**Pemulwuy Mixed Used Development (MP11_0093-Mod-3)
Response to Submissions**

I refer to the request to modify the project approval for the Pemulwuy mixed-use development, Redfern, to make minor internal and external amendments to Precinct 2 (MP11_0093 MOD 3).

4 Caroline Lane
1 : 200

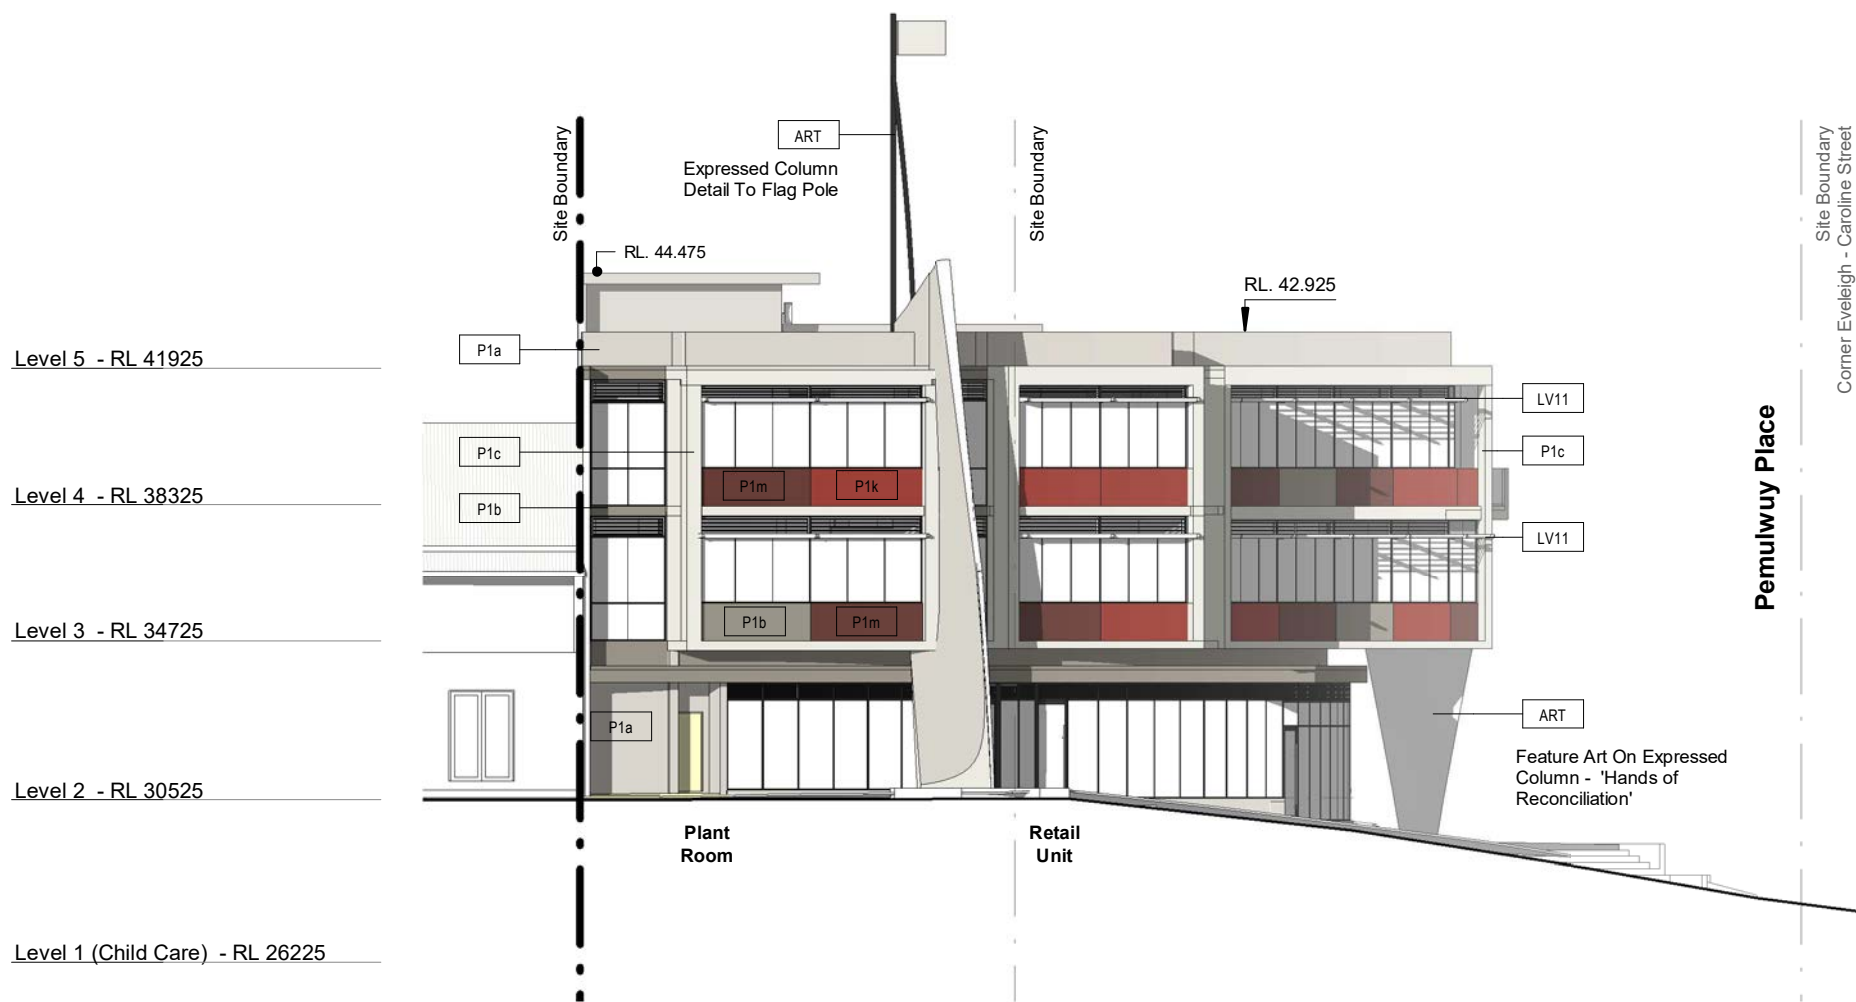
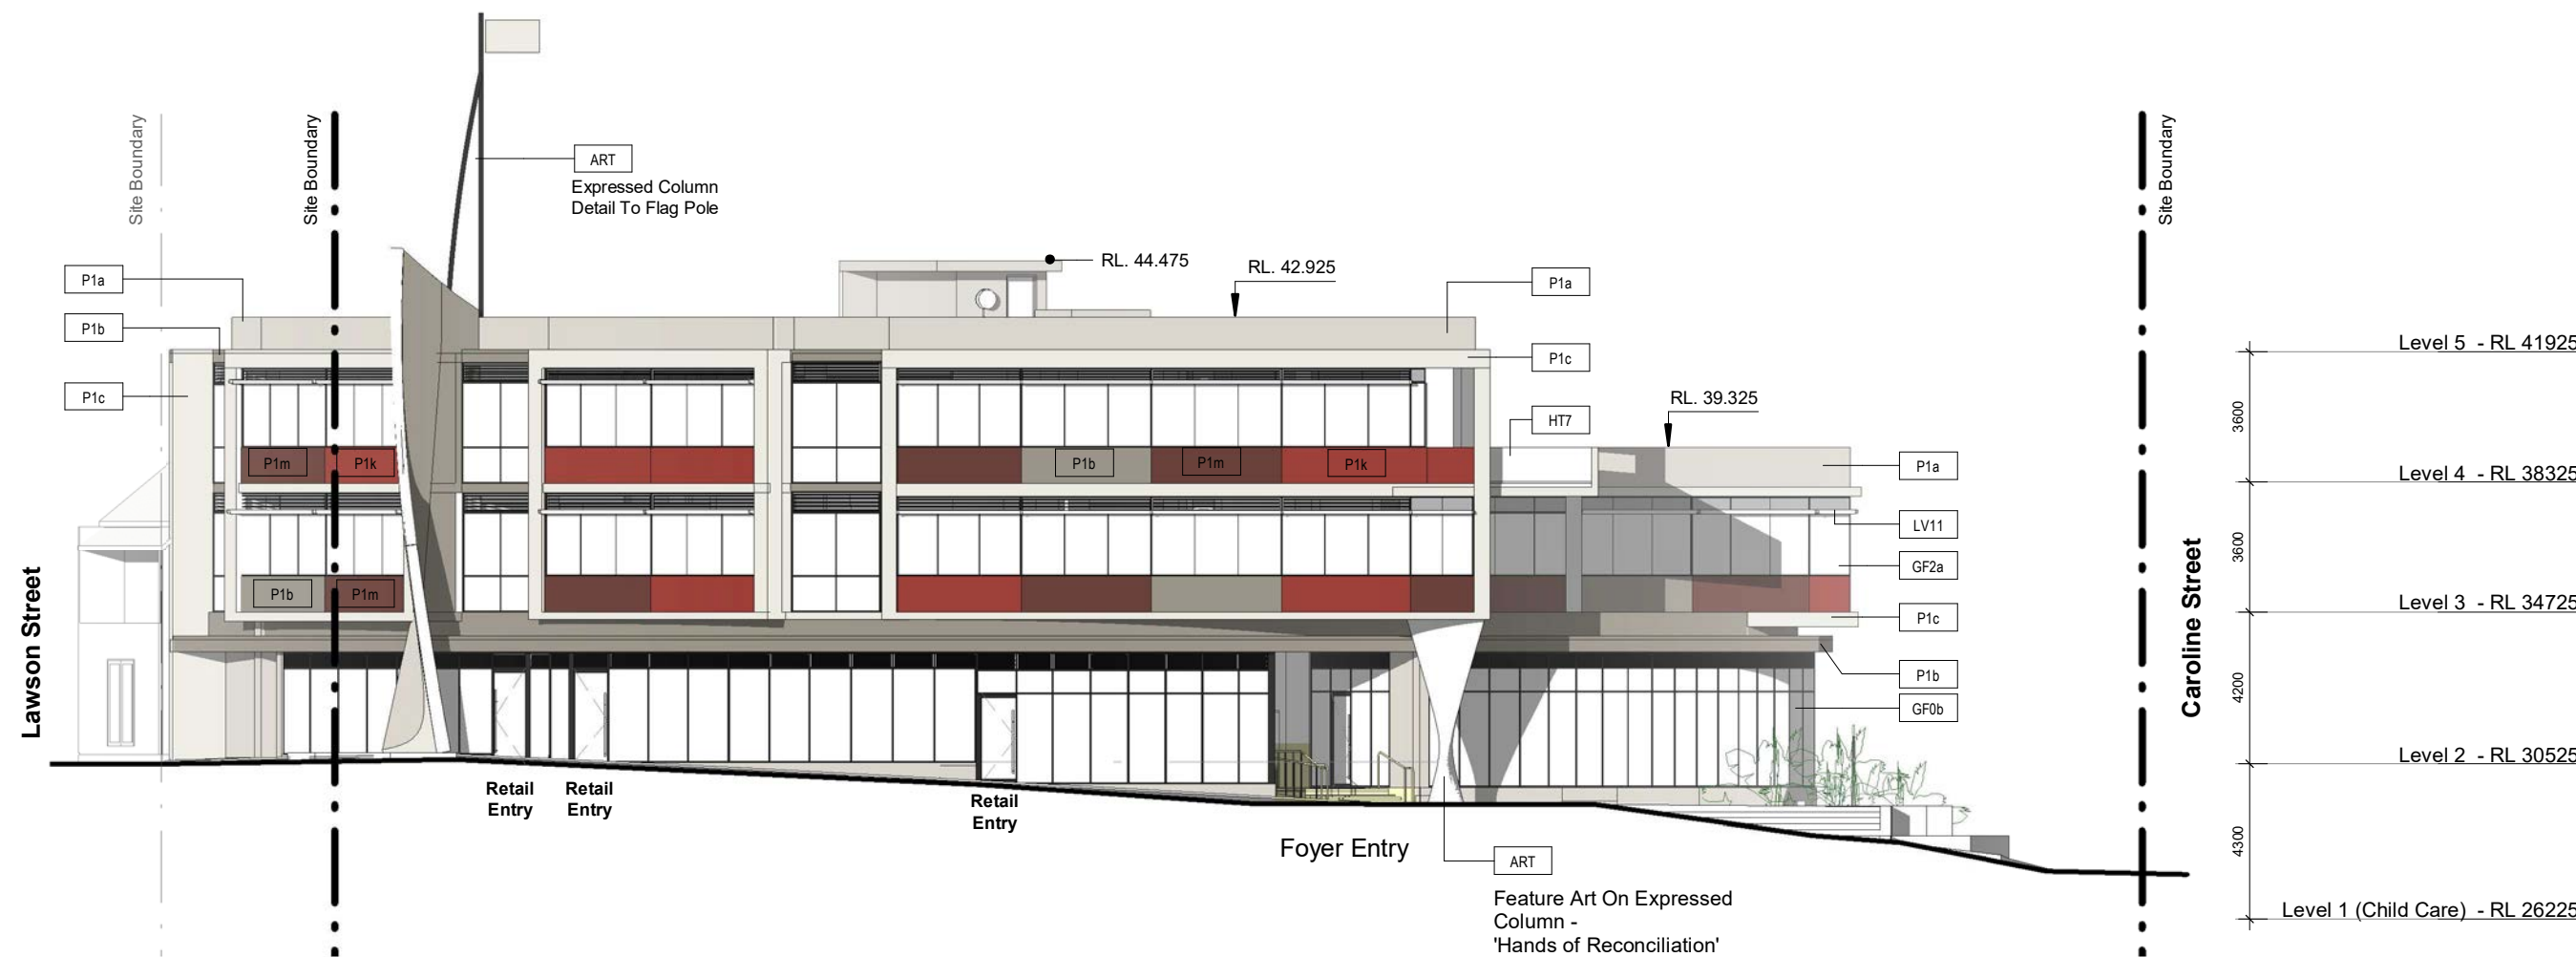
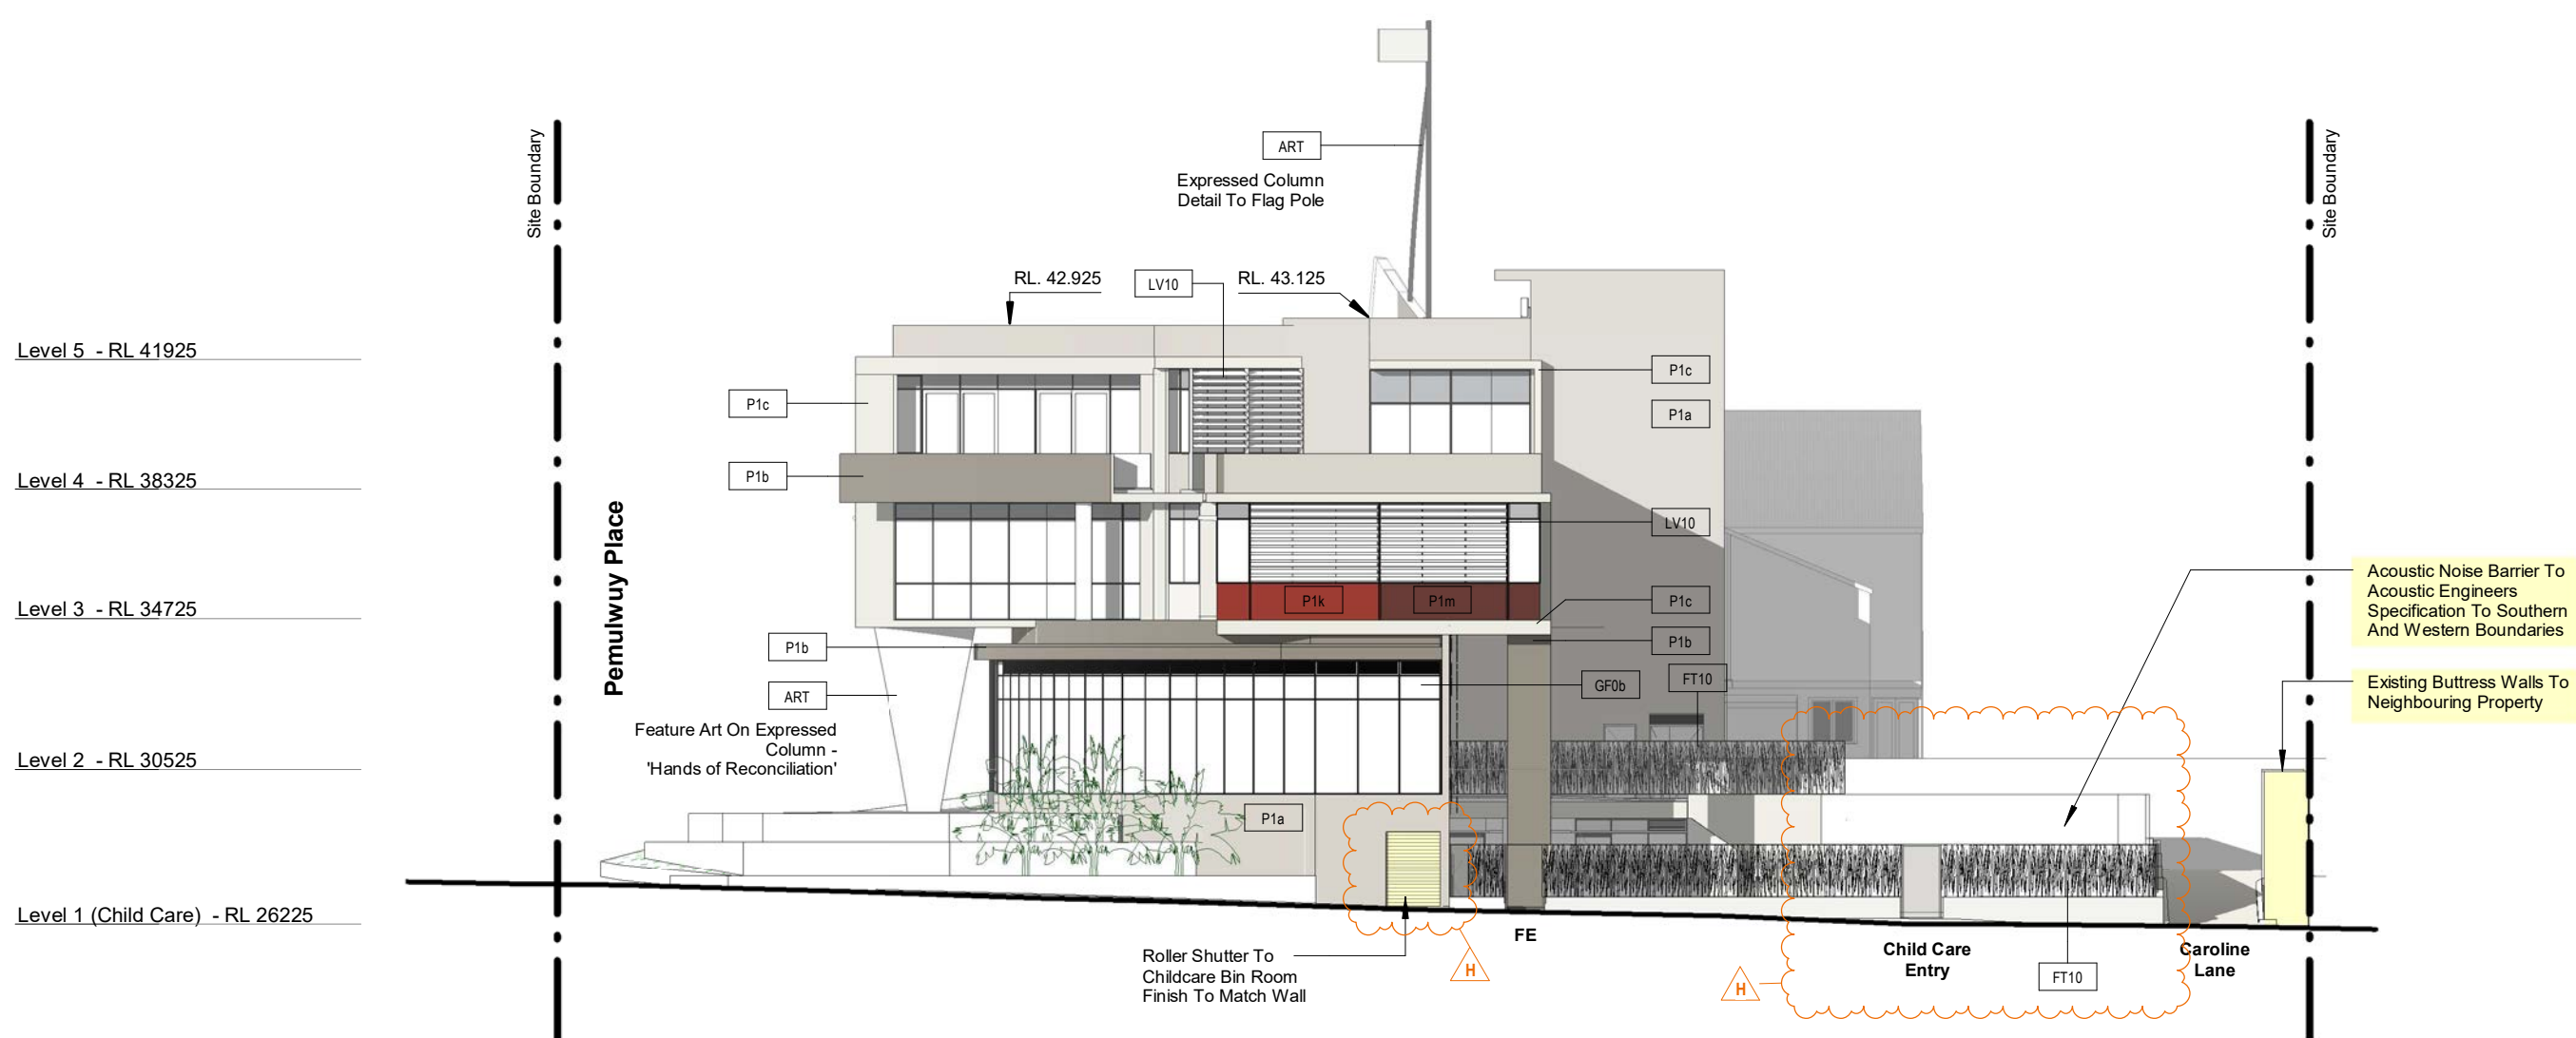
- provide further details of the proposed acoustic barrier to the southern and western elevations of the outdoor play area, including the extent of the barrier, height, materials and design to ensure a high quality appearance to the laneway
- provide an assessment of the noise and vibration impacts of the proposed plant room on level 2 on neighbouring properties and any mitigation measures required. Should impacts not be mitigated to an acceptable level, an alternate location may be required
- provide additional information in relation to the relocated waste management rooms and encroachments into the public domain, in response to the concerns raised in Council's submission.
